## GG119 ROAD SAFETY AUDIT RESPONSE REPORT

Project Title:	Roslyn Avenue, Netherton, Huddersfield
Project Team:	Harron Homes / Elston Engineering Ltd
RSA Report Stage	Stage 1
RSA Organisation:	Sanderson Associates Consulting Engineers
RSA Report Reference:	Stage 1 Road Safety Audit
RSA Report Issue Date:	March 2026
Report Title:	Stage 1 Road Safety Audit
Reference:	400187-001

This Road Safety Audit Response Report relates to a Stage 1 Road Safety Audit carried out by Sanderson Associates Consulting Engineers for the proposed residential development on land off Roslyn Avenue, Netherton. The development comprises the construction of 82no. residential properties with associated adopted highways.

Drawing Number:	Drawn by:	Checked by:
EE100008-306	SG	SG
Project ref:	date:	original paper size:
EE100008	06.02.2026	A1
scale:		
1:500

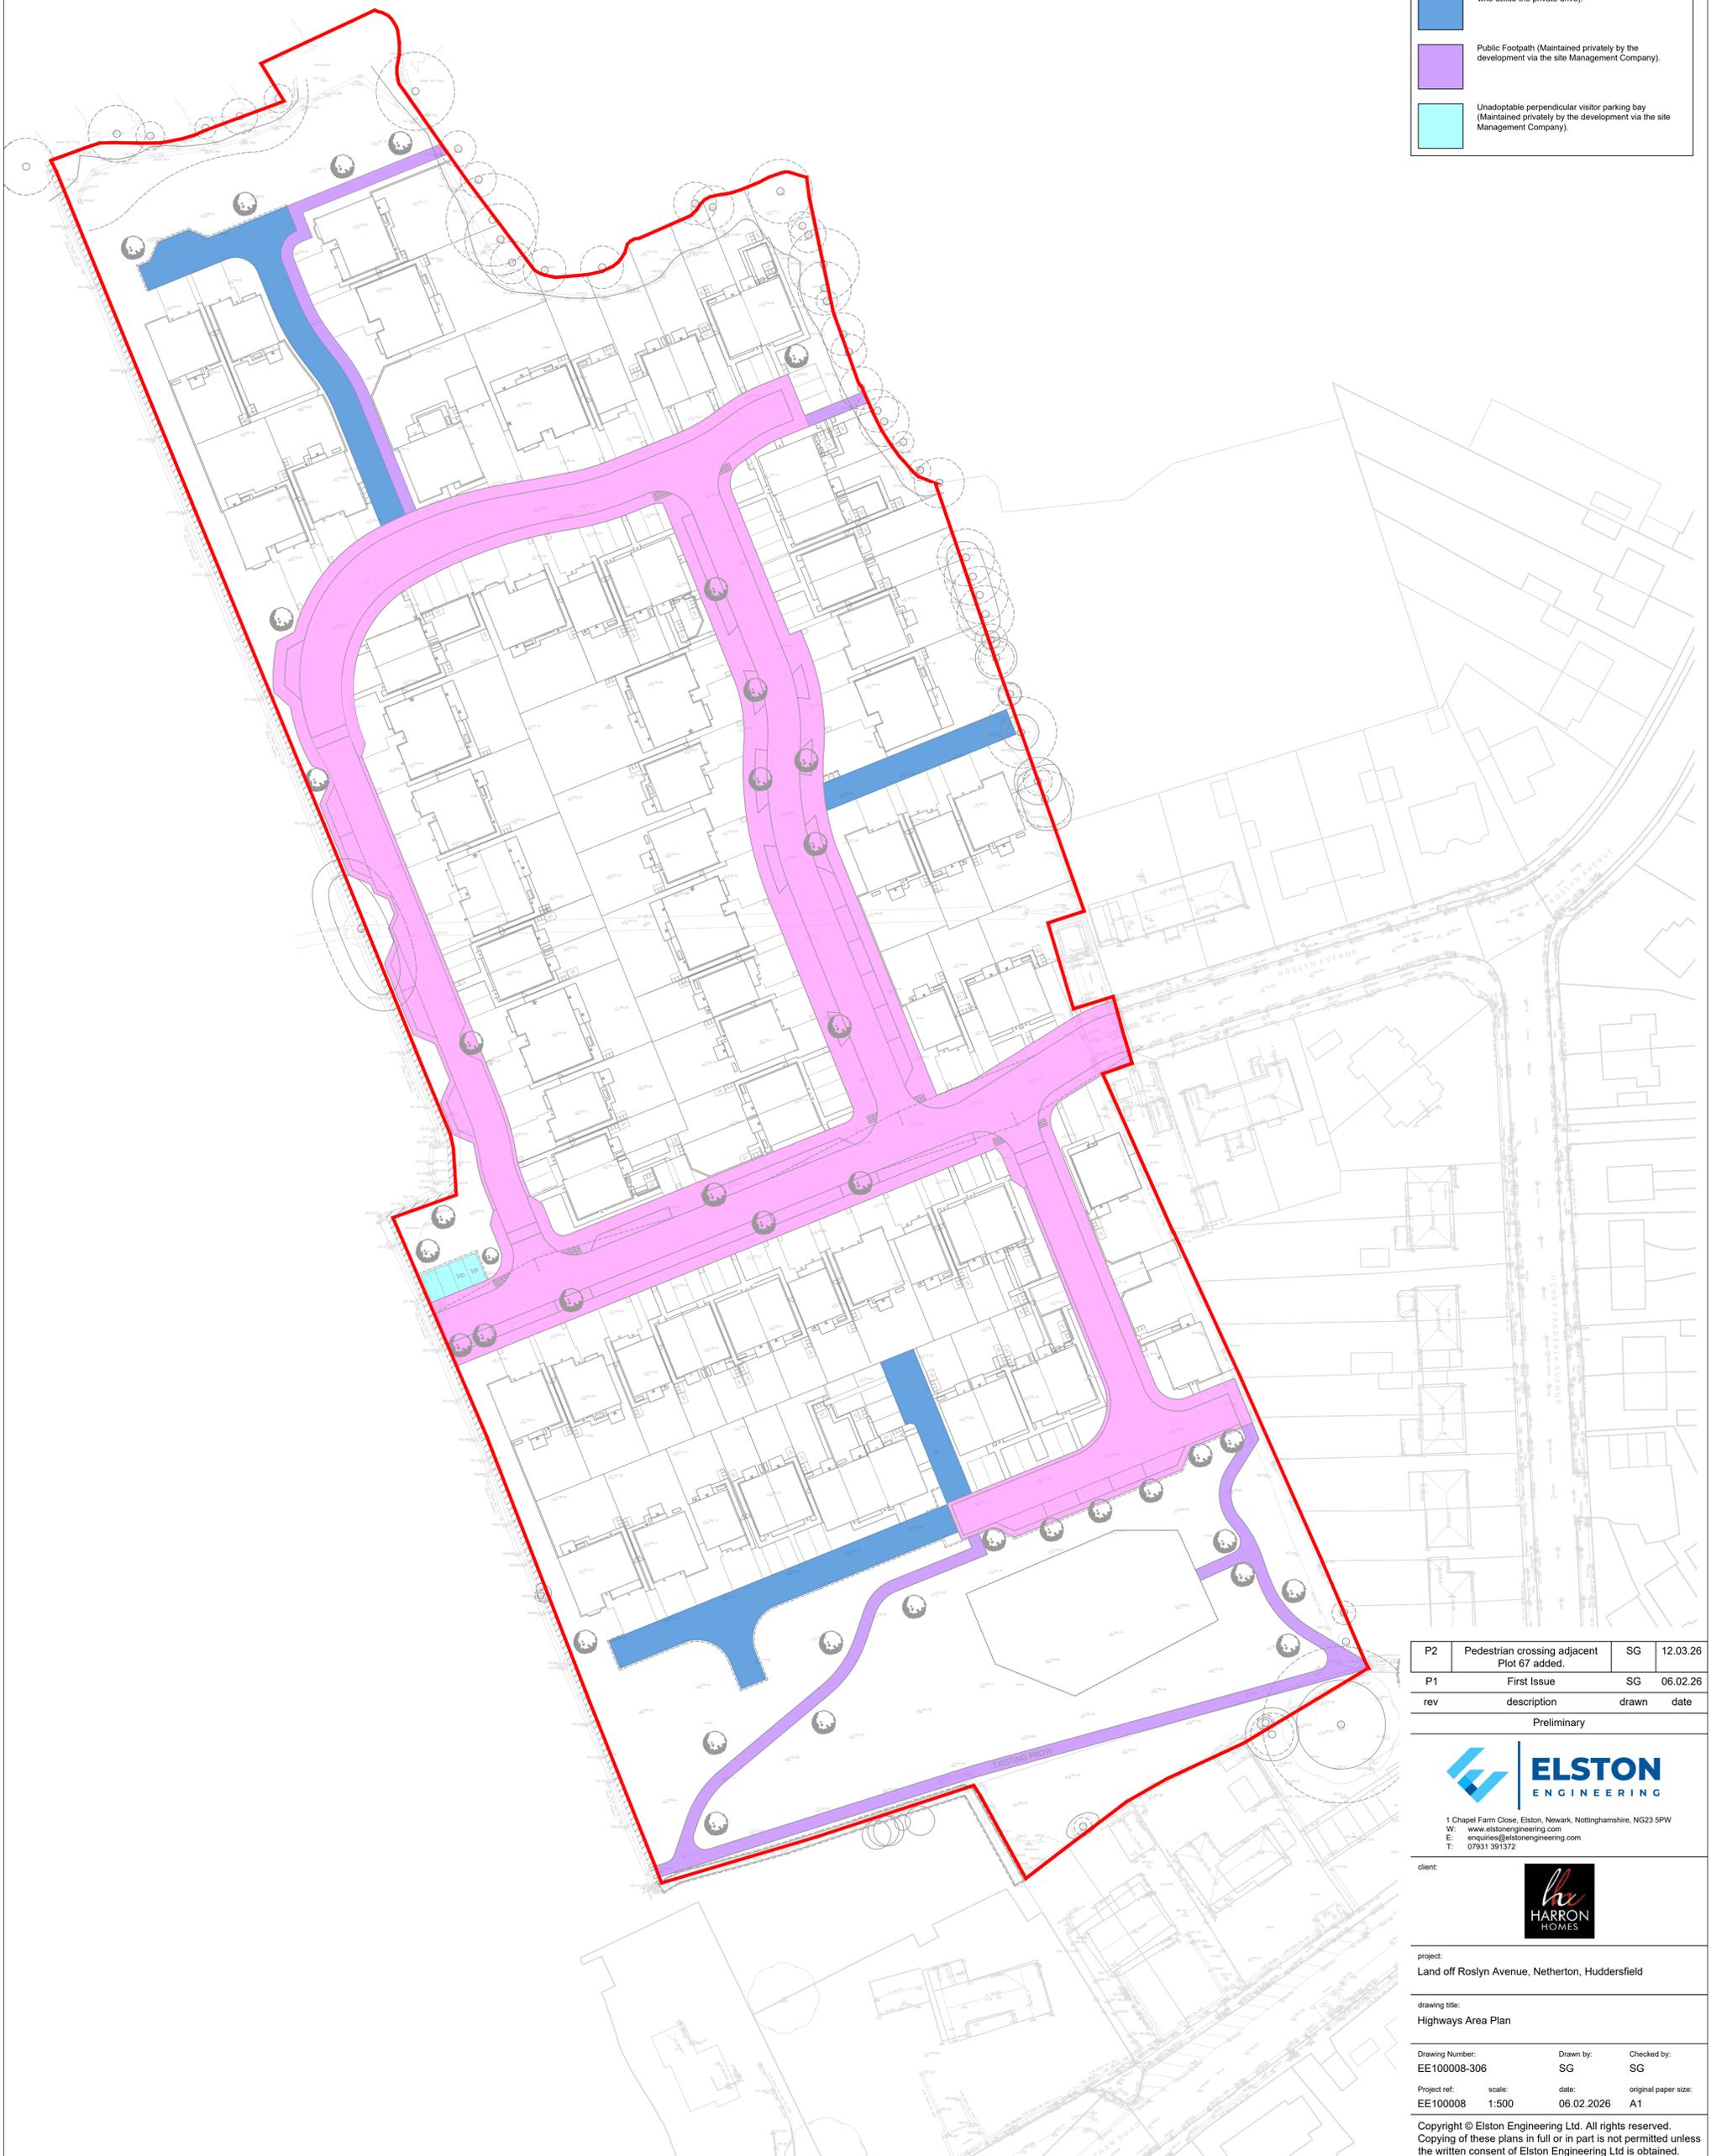
Lack of dropped crossing.

Proposed dropped kerb pedestrian crossing facilities are indicated on the Section 38 Layout Plan at the majority of significant junctions within the development. However, no dropped crossing provision is shown at the junction located at the north-east end of the loop road. There is a footpath link to and from the development adjacent to Plot 67 that connects to this junction, which is likely to generate pedestrian movements across the carriageway at this location. The absence of a dropped crossing may therefore result in an inconsistent level of pedestrian provision and may create difficulties for mobility-impaired users, wheelchair users, and those with pushchairs attempting to cross the carriageway. This may discourage pedestrians from using the footway network as intended or lead to informal crossing at locations without appropriate tactile paving or level access.

It is recommended that a dropped kerb pedestrian crossing point be included in the design at this junction including appropriate tactile paving.

Tactile paved pedestrian crossing included at the junction adjacent Plot 67 to aid pedestrian movements.

Drawing Number: EE100008-301  
 Project ref: EE100008  
 scale: 1:500  
 date: 30.09.2025  
 Checked by: SG  
 original paper size: A1

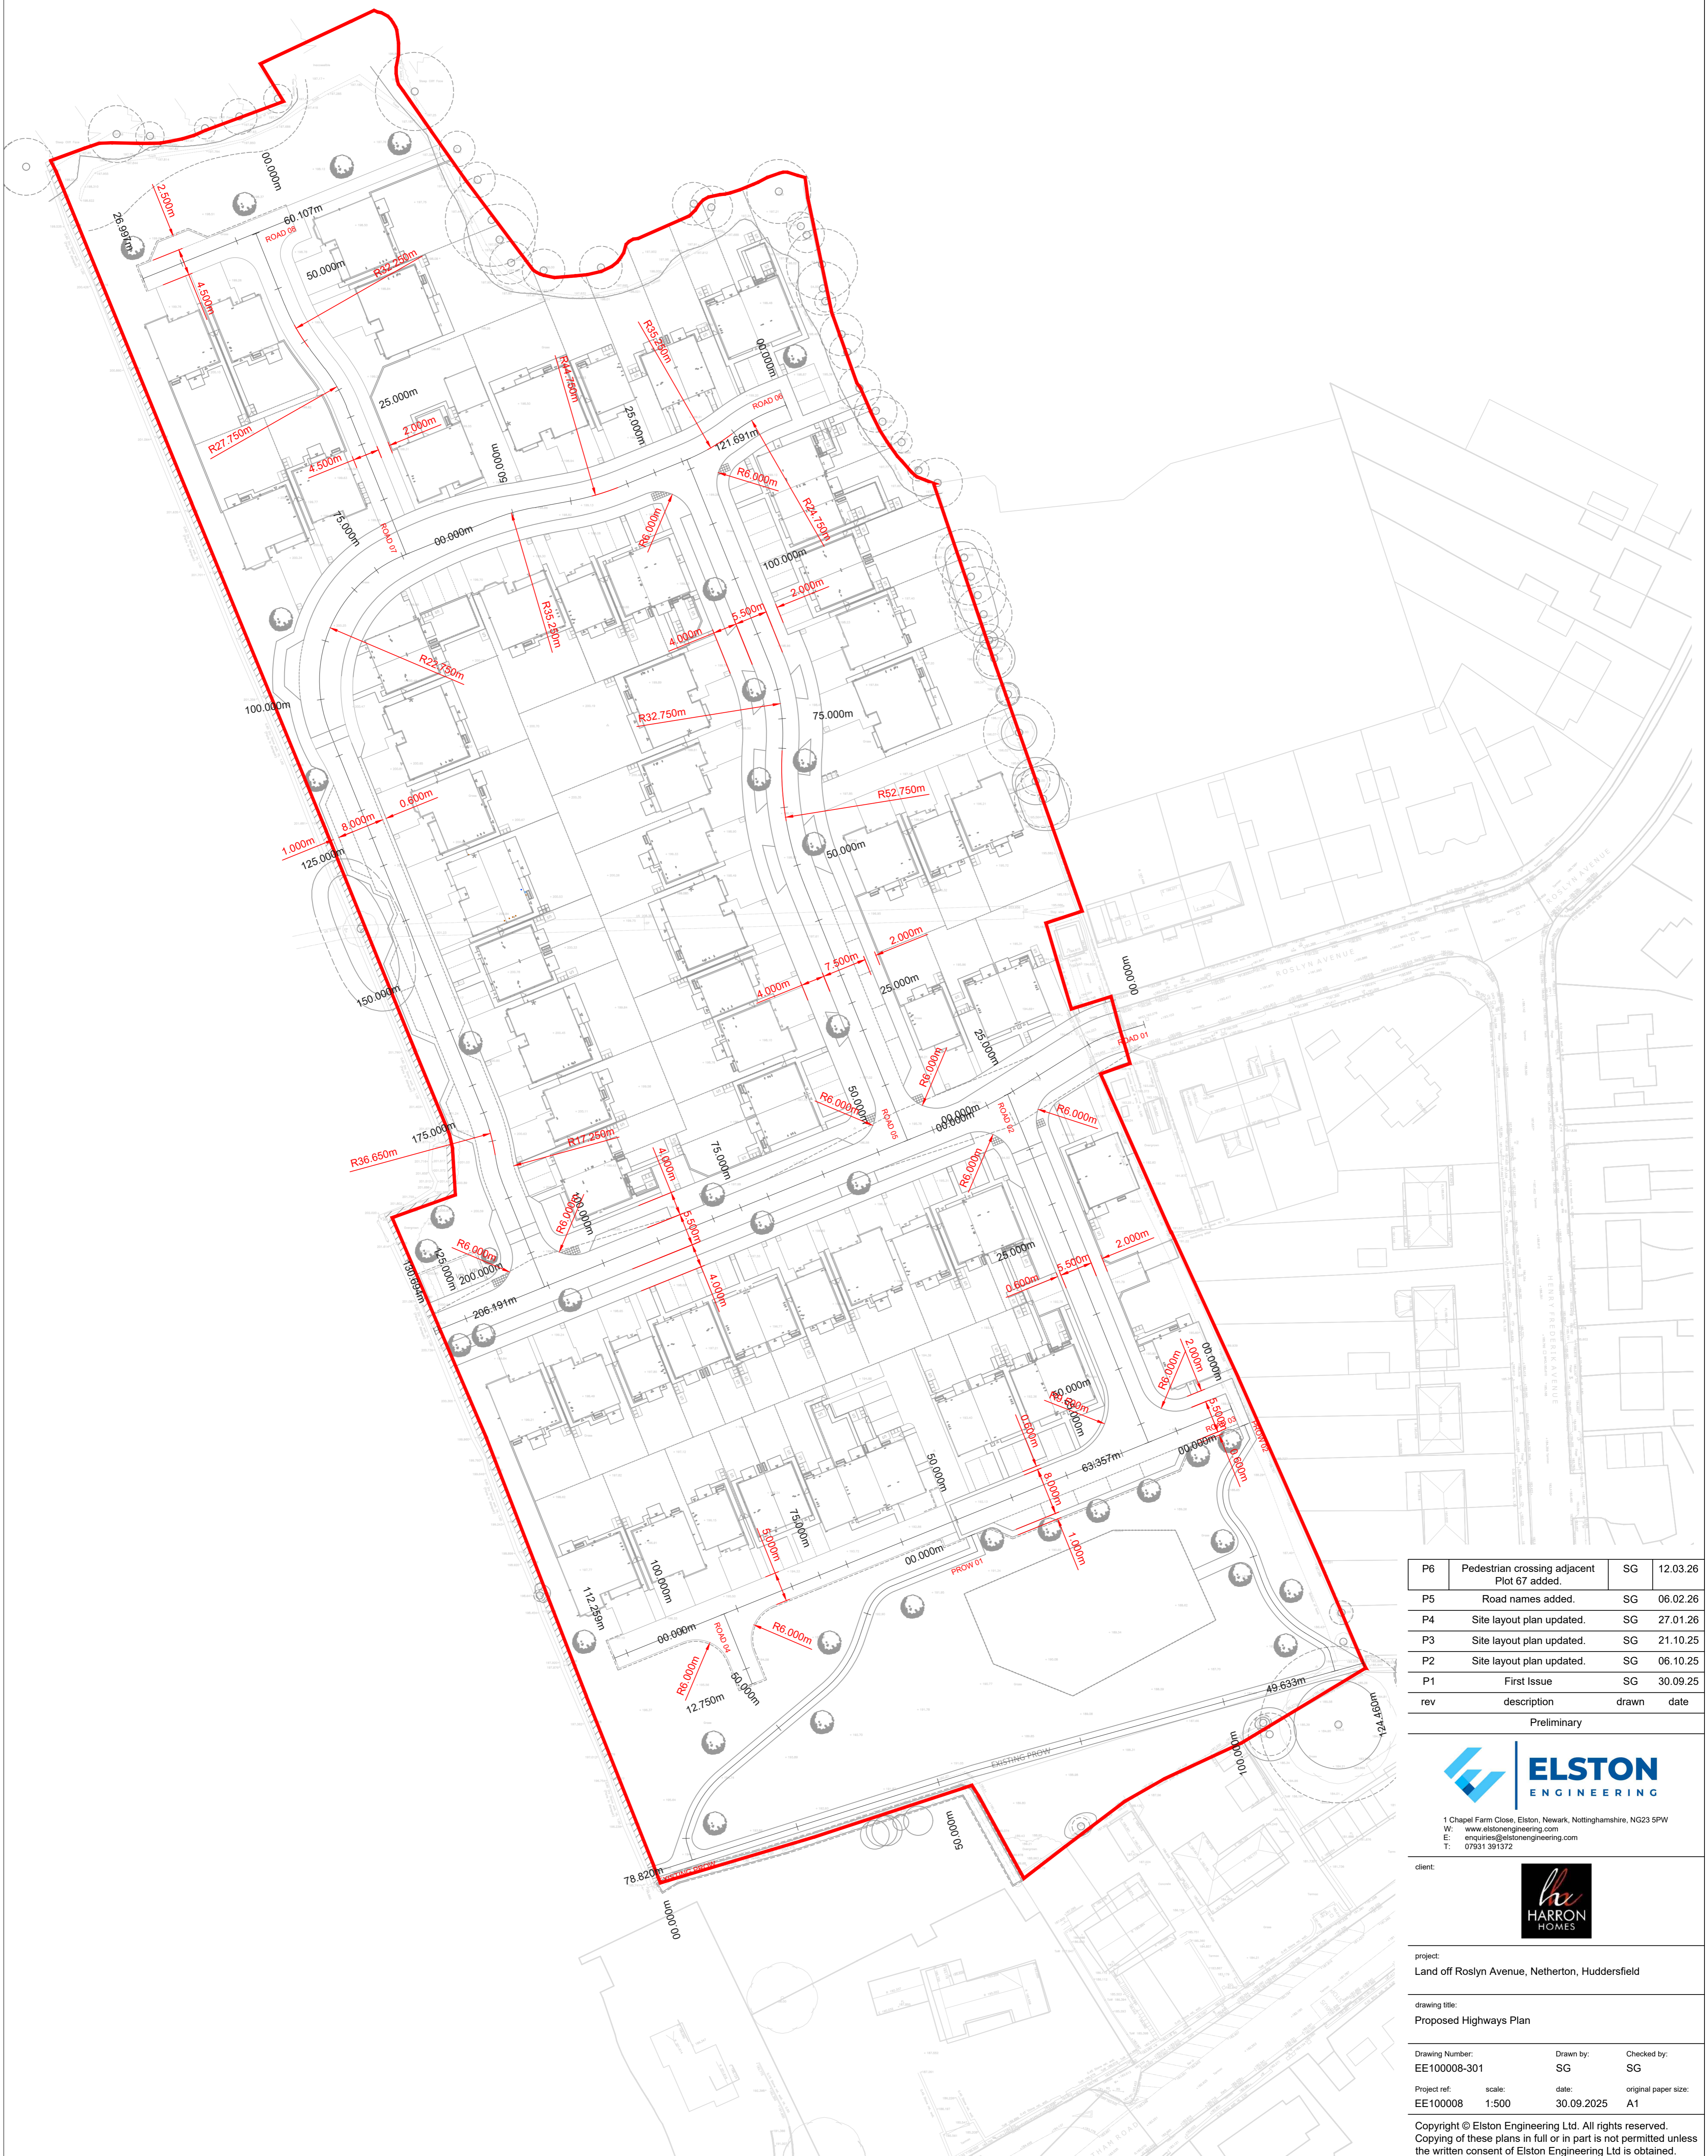
Dropped crossings with tactile paving are now shown on the drawings (including EE100008-301 P06) at the junction adjacent to Plot 67, and are acceptable in principle. However, the location of this new dropped crossing may be better inset further into the junction, similar to the arrangement shown at the junction further to the south. This change can be picked up at the detailed design stage as part of the S38 technical approval process, and reviewed further as part of the required Stage 2 RSA process.

All tactile paving and dropped crossing designs to be reviewed and agreed with S38 Team at the detailed design stage.
